Addendum No. 1

RE: Contract # C204682

Ashe County (BR-0002)

BRIDGE #40008 ON NC-194 OVER NORTH FORK NEW RIVER

STANDARD TEMPORARY SHORING

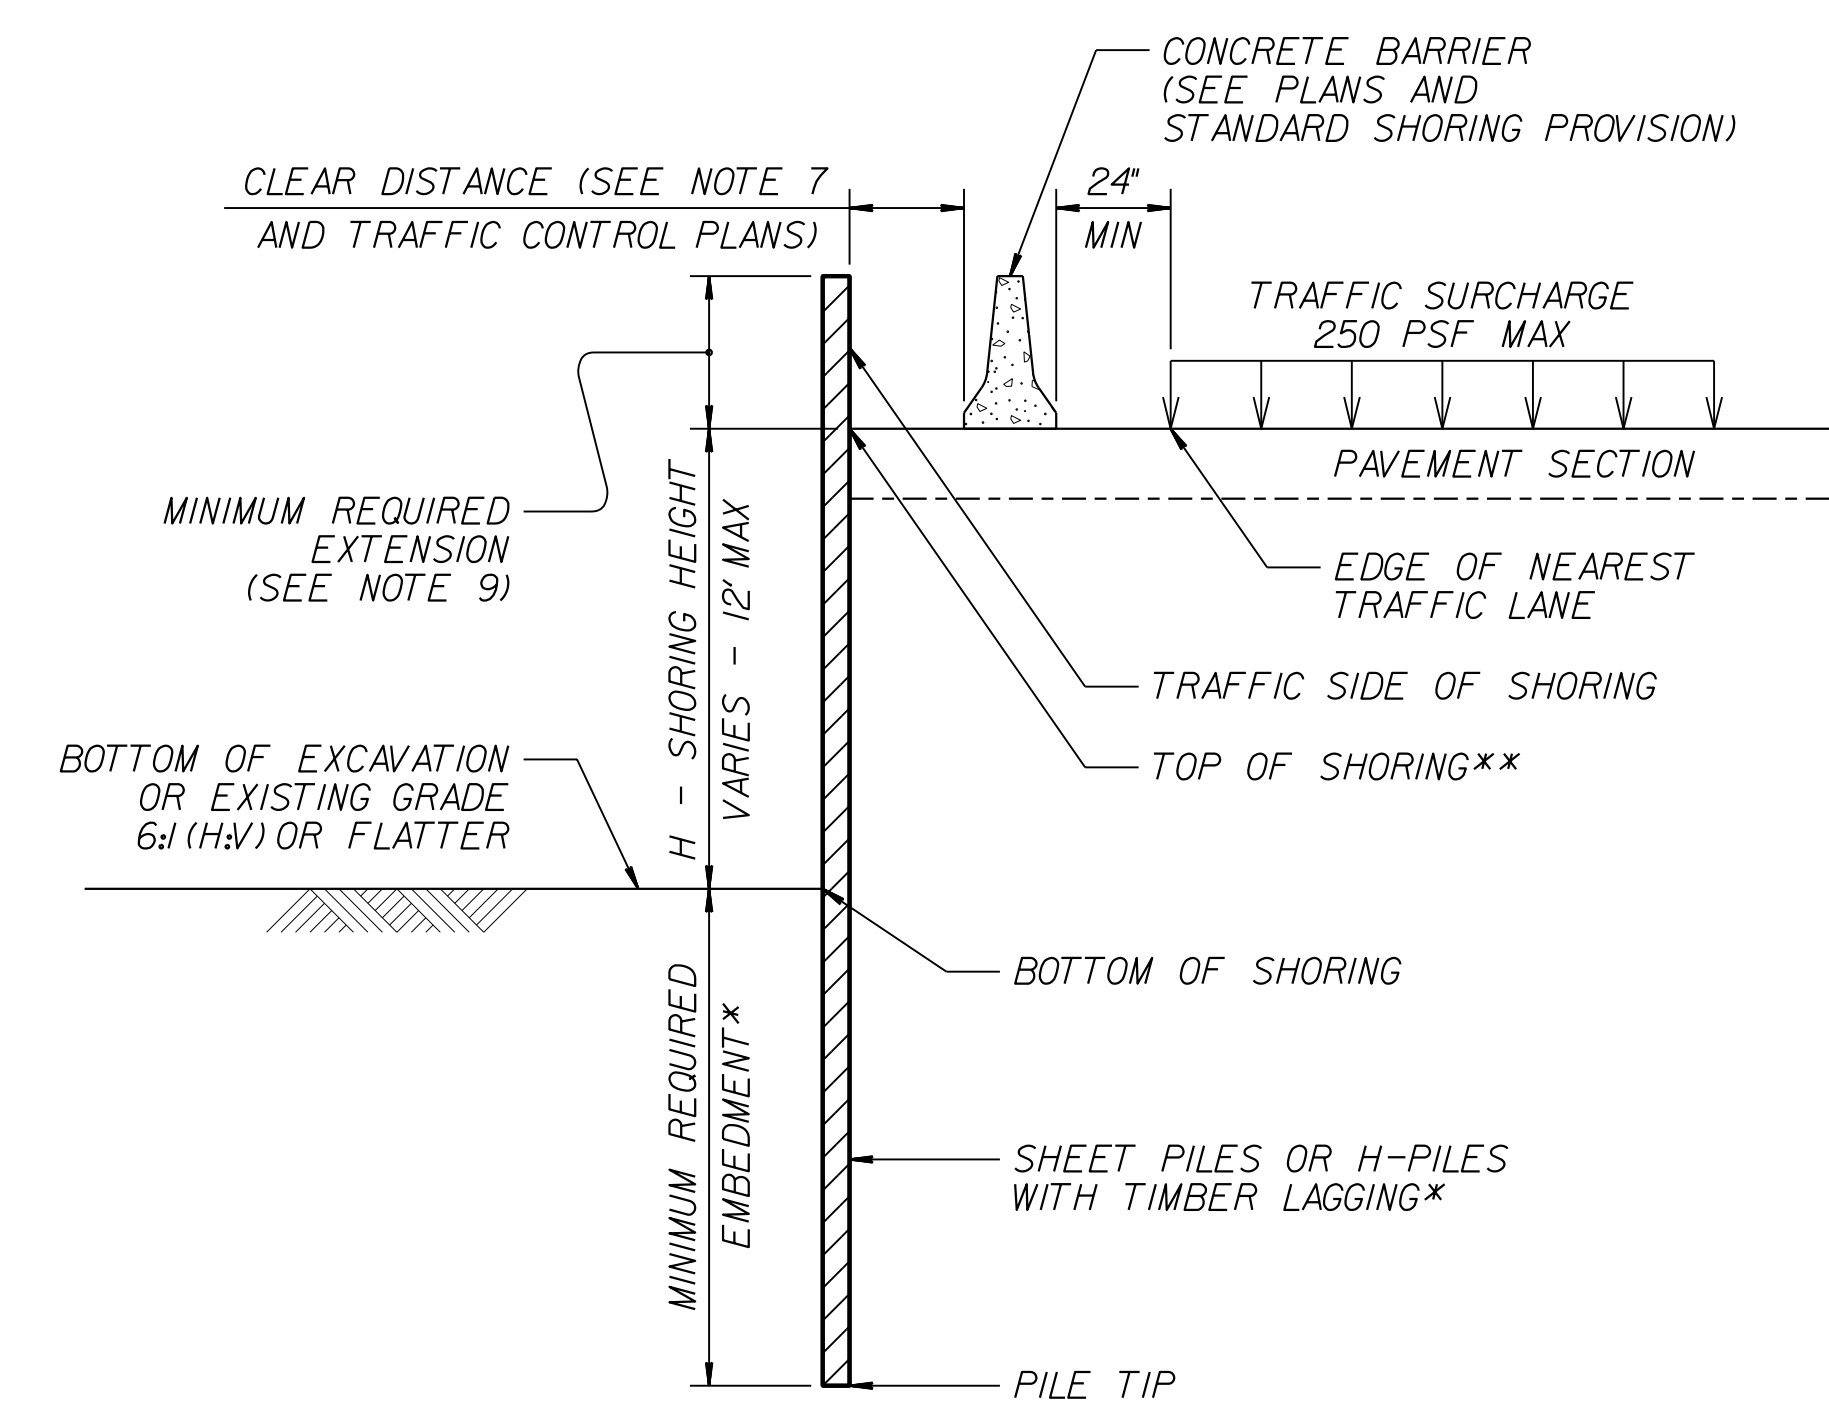
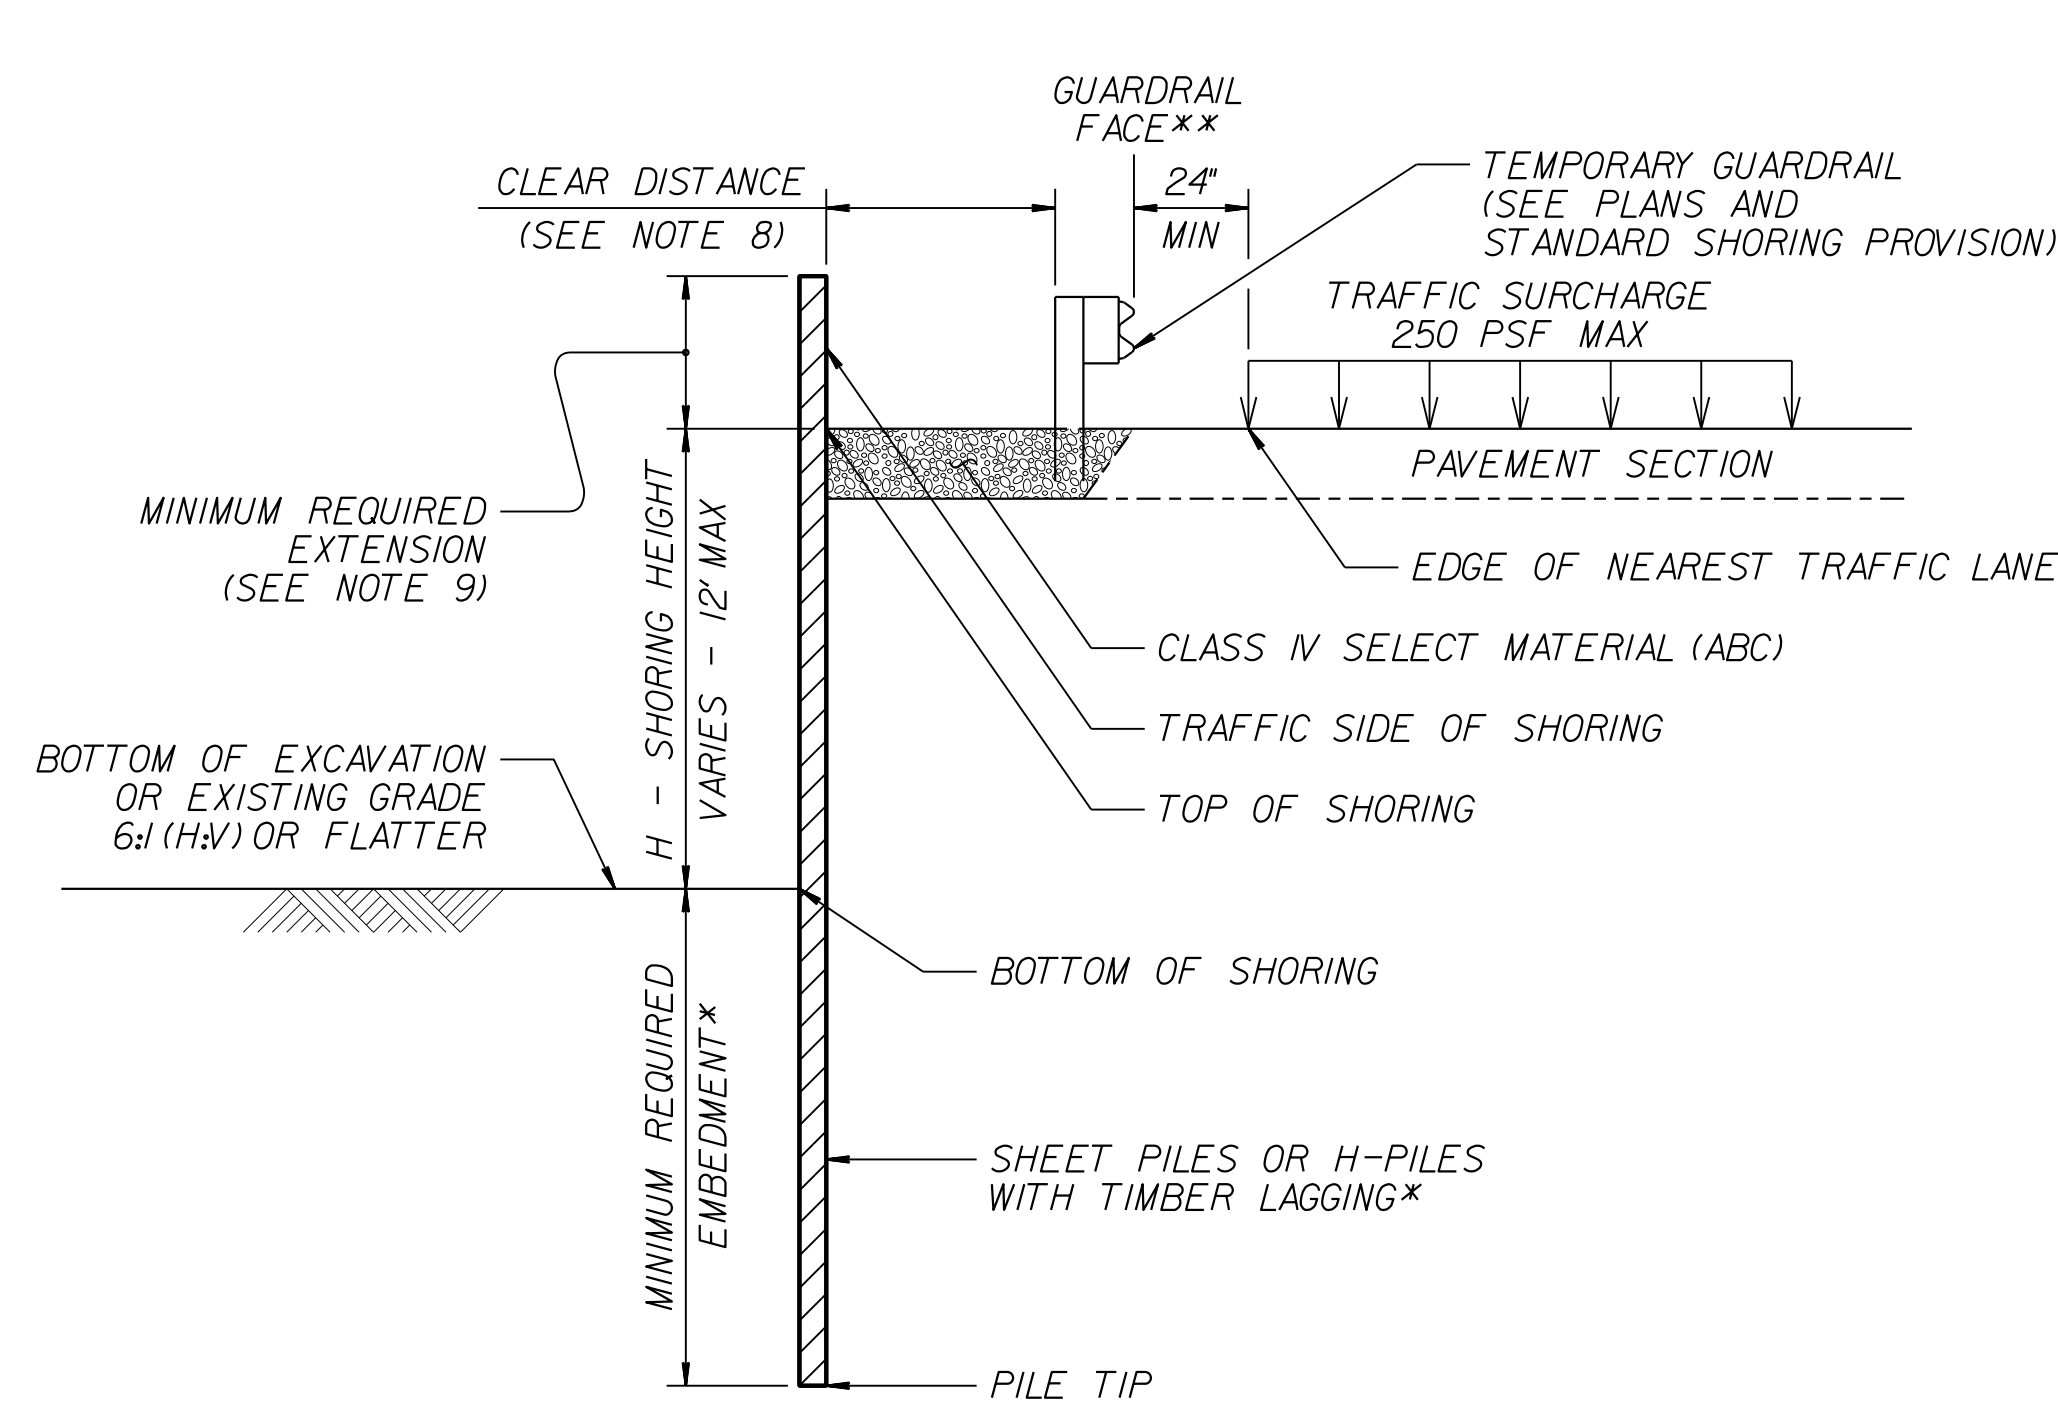
Page No.	Revisions
Proposal Cover	Note added that reads "Includes Addendum No. 1 Dated 11-04-2021"
GT 3.1 thru GT 3.4	Revised Unit Project Special Provision entitled STANDARD SHORING to update from (1-16-18) Standard Shoring provision to (10-19-21) Standard Shoring provision.
GT 4.1 thru GT 4.9	Revised Unit Project Special Provision entitled TEMPORARY SOIL NAIL WALLS to update from (1-16-18) Temporary Soil Nail Walls provision to (10-19-21) Temporary Soil Nail Walls provision.

STANDARD SHORING:**(10-19-21)****Description**

Standard shoring includes standard temporary shoring and standard temporary mechanically stabilized earth (MSE) walls. At the Contractor's option, use standard shoring as noted in the plans or as directed. When using standard shoring, a temporary shoring design submittal is not required. Construct standard shoring based on actual elevations and shoring dimensions in accordance with the contract and Geotechnical Standard Detail No. 1801.01 or 1801.02.

Based on actual shoring height, positive protection, groundwater elevation, slope or surcharge case and traffic impact at each standard temporary shoring location, use sheet piles with the minimum required section modulus or H-piles with the sizes shown in Geotechnical Standard Detail No. 1801.01. Use untreated timber with a thickness of at least 3" and a bending stress of at least 1,000 psi for timber lagging.

Based on actual shoring height, positive protection, groundwater elevation, slope or surcharge case and traffic impact at each standard temporary shoring location, install piles with the minimum required embedment and extension for each shoring section in accordance with Geotechnical Standard Detail No. 1801.01. For concrete barrier above and next to standard temporary shoring and temporary guardrail above and attached to standard temporary shoring, use “surcharge case with traffic impact” in accordance with Geotechnical Standard Detail No. 1801.01. Otherwise, use “slope or surcharge case with no traffic impact” in accordance with Geotechnical Standard Detail No. 1801.01. If refusal is reached before driven piles attain the minimum required embedment, use drilled-in H-piles with timber lagging for standard temporary shoring.
